Subject: RE: P/46/25/DOC - CMP and Soil Resources Plan

Condition 17 (CMP and Soil Resources Plan)

SCALE 1:1250
DATE November 2024
DRAWN TS
CHECKED PZ
DRAWING TITLE
Pagham
Site Setup Plan

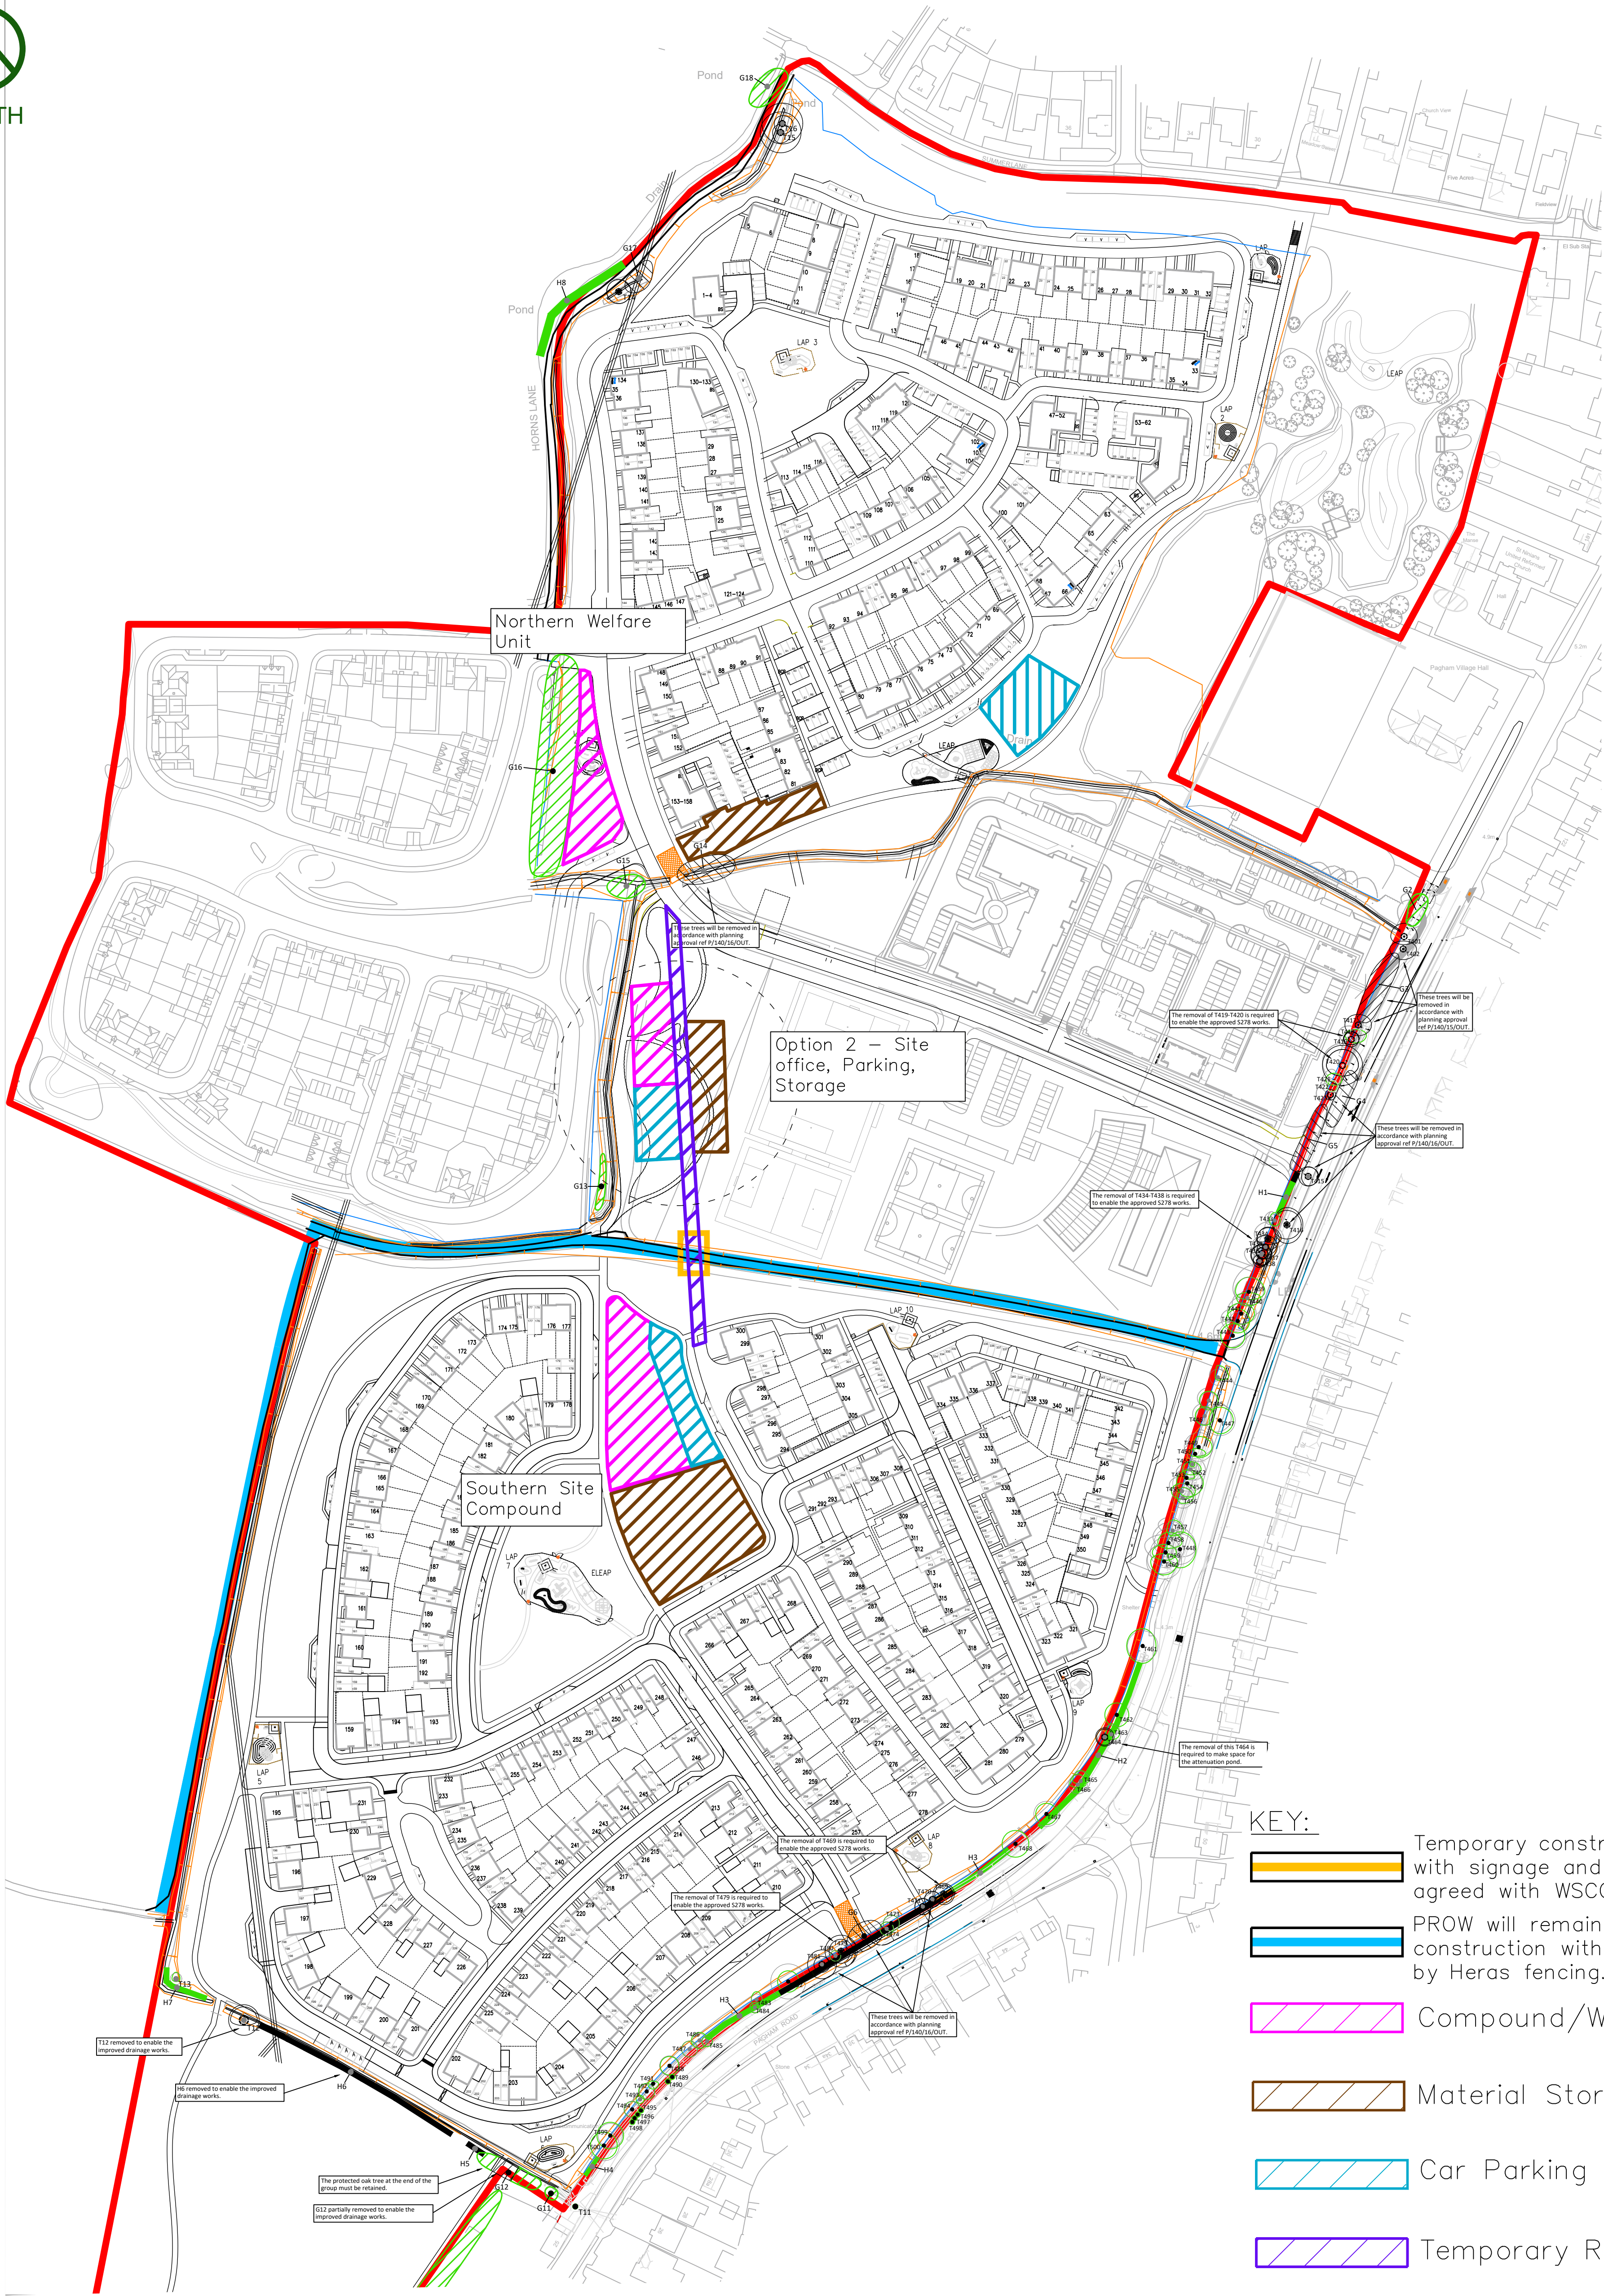
Could you also please amend the red line within Appendix 1 so that it does not include Church Barton house. This obviously would not discharge their condition, but more so for clarity. **Done – plan updated**

3. Appendix 1 Plan shows wheel washing, compounds etc, however on Page 3, it is stated that this is indicative, which would not allow the LPA sufficient control. This would need to be amended. **Done - 'Indicative' removed from plan**

- a. Also, the wheel washing on the south access is acceptable. However, the other wheel washing facility is quite far into the site which would raise concerns about the mud tracking. **The plan has been updated to show the wheel wash being moved once the access is created and in use.**

4. Please can you add an annotation to the appendix plan to be clear that the Tree Protection barrier will be installed prior to compound set up and the compound will be outside of the 10.3m protection barrier. **Done – plan updated**
